<b>Application Reference Number:</b>	2026/0077.
--------------------------------------	------------

<b>Application Type:</b>	<i>Change of Use.</i>
--------------------------	-----------------------

<b>Proposal Description:</b>	<i>Change of use of existing outbuildings within the residential curtilage of a dwellinghouse (Use Class C3) to facilitate a small-scale, home based food production and delivery business (Sui Generis), operating ancillary to the residential use (Retrospective).</i>
<b>Location:</b>	<i>19 Redhill Avenue, Kendray, Barnsley, S70 3LA.</i>

DRAWING DESCRIPTION: *SHED plan*
Steel container for preparing takeaway meals

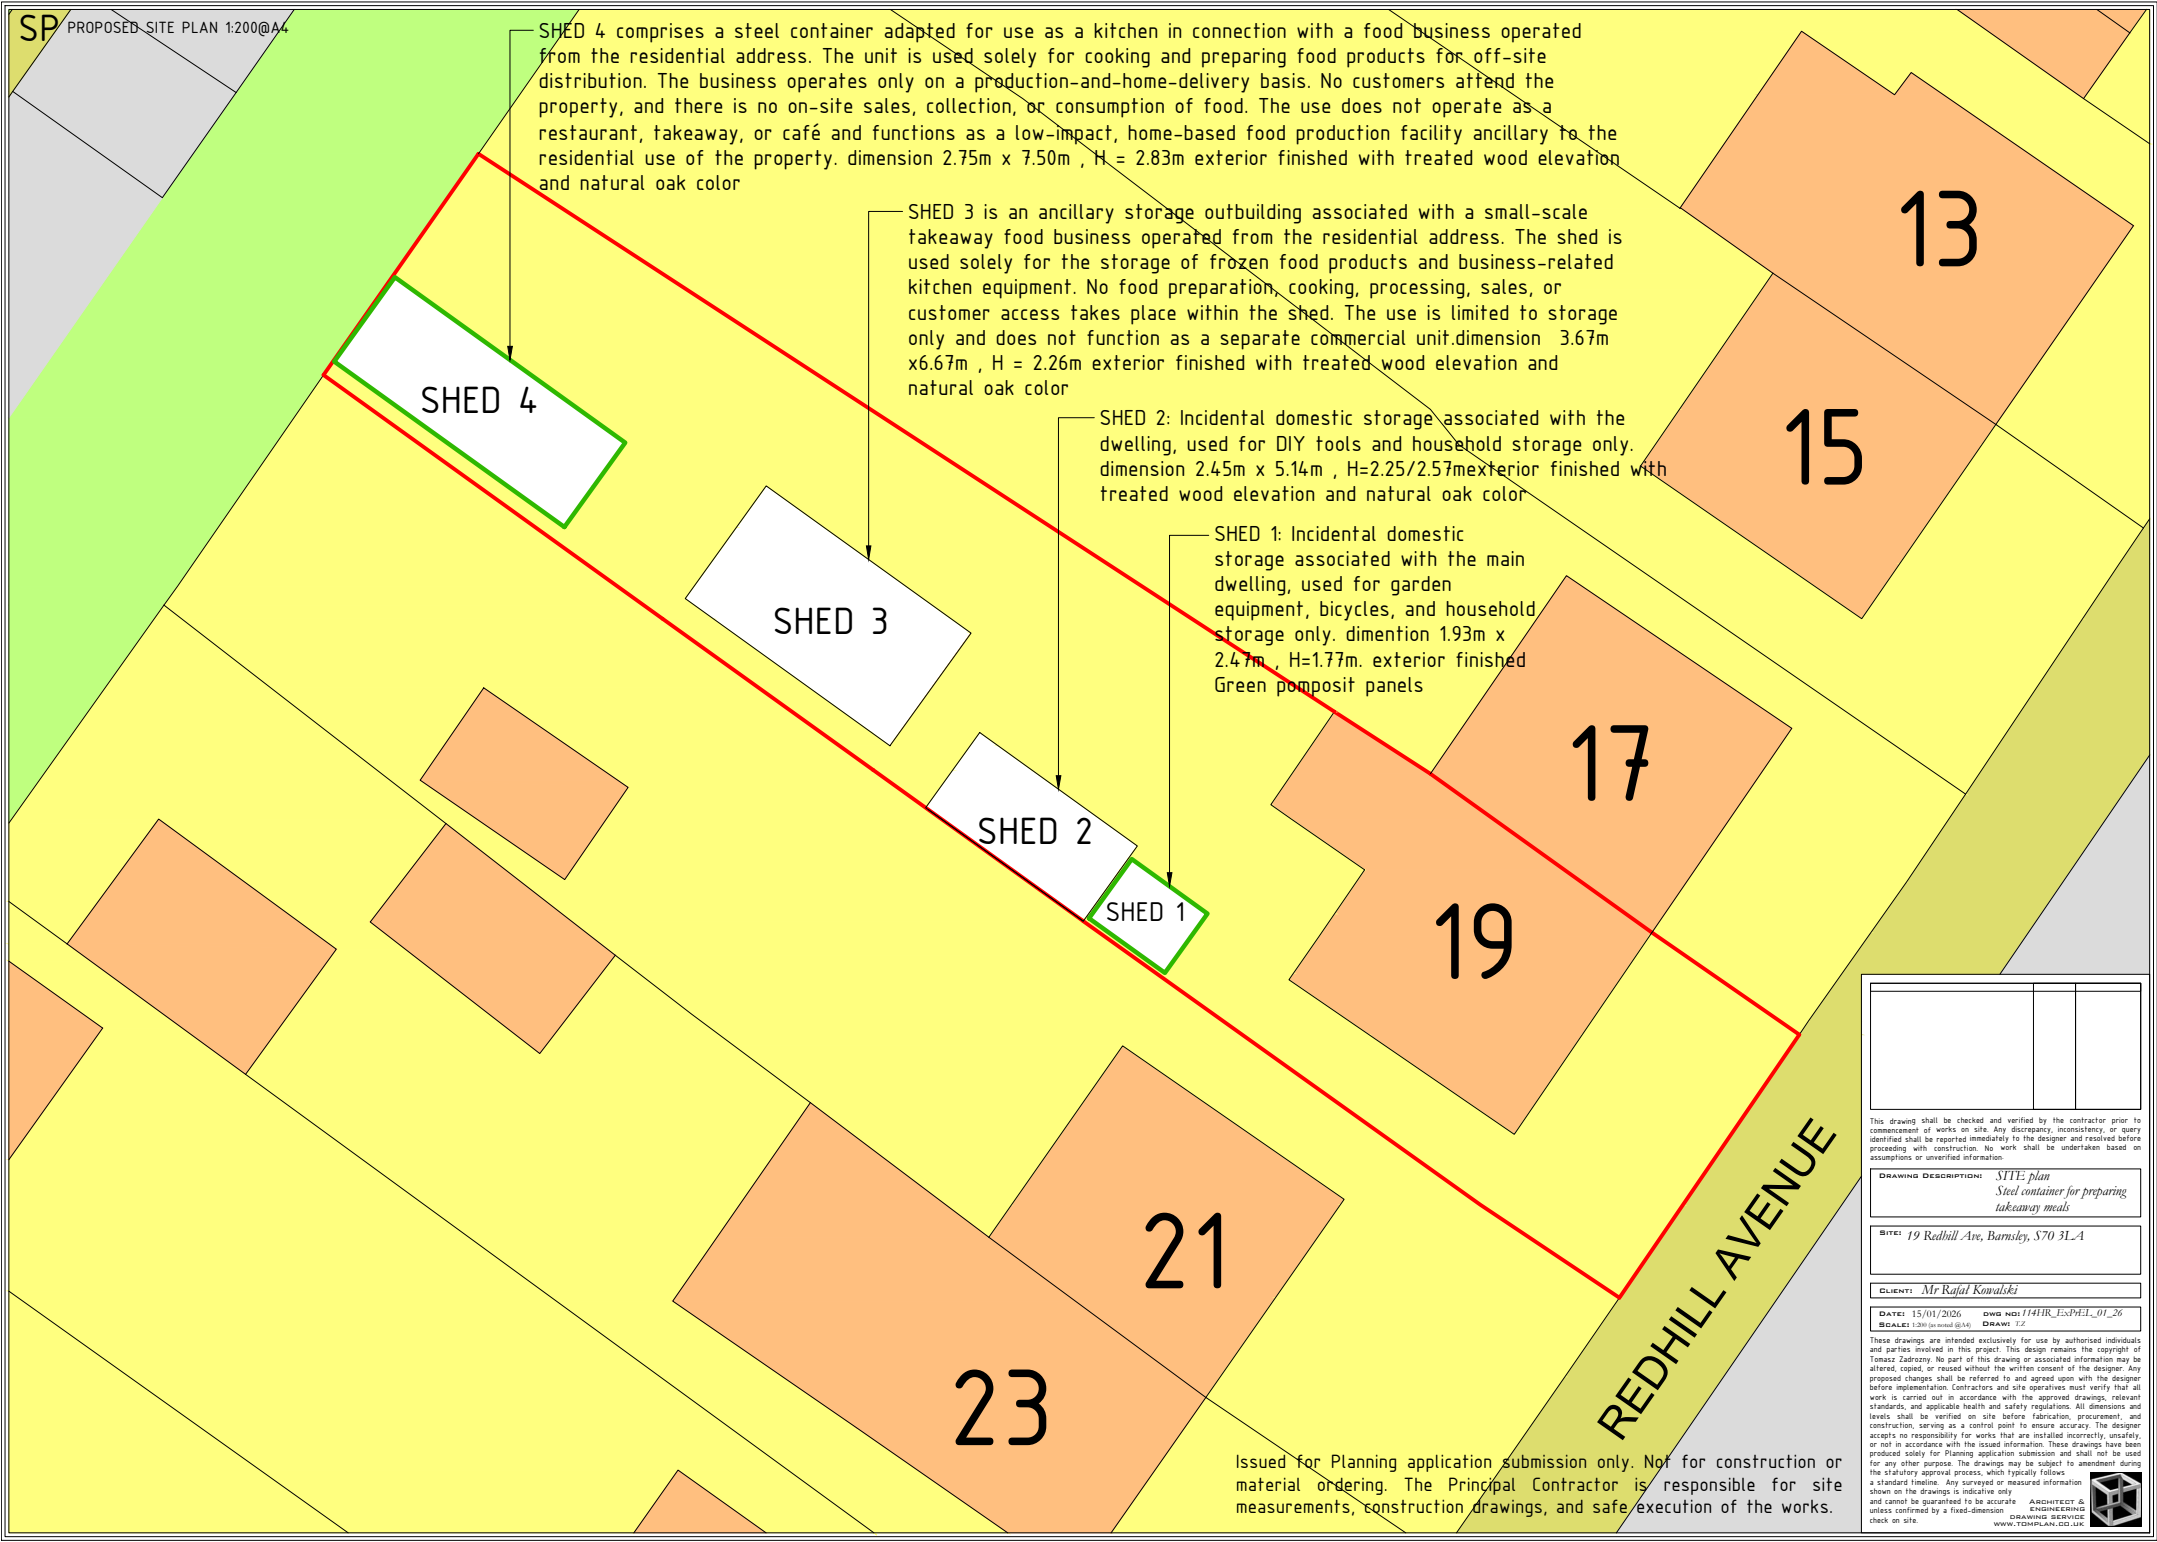
The steel container, however, is notably larger in scale and footprint and, by its very nature, appears bulky and utilitarian in its design and appearance despite elements of vertical timber cladding.

The siting of the container therefore creates a harsh, industrial type presence which appears visually jarring and incongruous with the surrounding residential setting. The arising harm is exacerbated by existing topography levels, the exposed bright green colour of the container in some places, and the fascia signage, which results in the container having greater prominence and further emphasises its commercial nature in a residential setting. The container is visible from the surrounding public realm, including from Doncaster Road at the entrance of the Kendray Hospital site, and from within the site itself, where the harmful impacts of the container are more clearly visible.

3. In the opinion of the local planning authority, the siting of the container creates a harsh, industrial type presence which appears visually jarring and incongruous with the surrounding residential setting. The arising harm is exacerbated by existing topography levels, the exposed bright green colour of the container in some places, and fascia signage, which results in a greater prominence, and further emphasises the commercial nature of the container in a residential setting, contrary to Local Plan Policy D1.
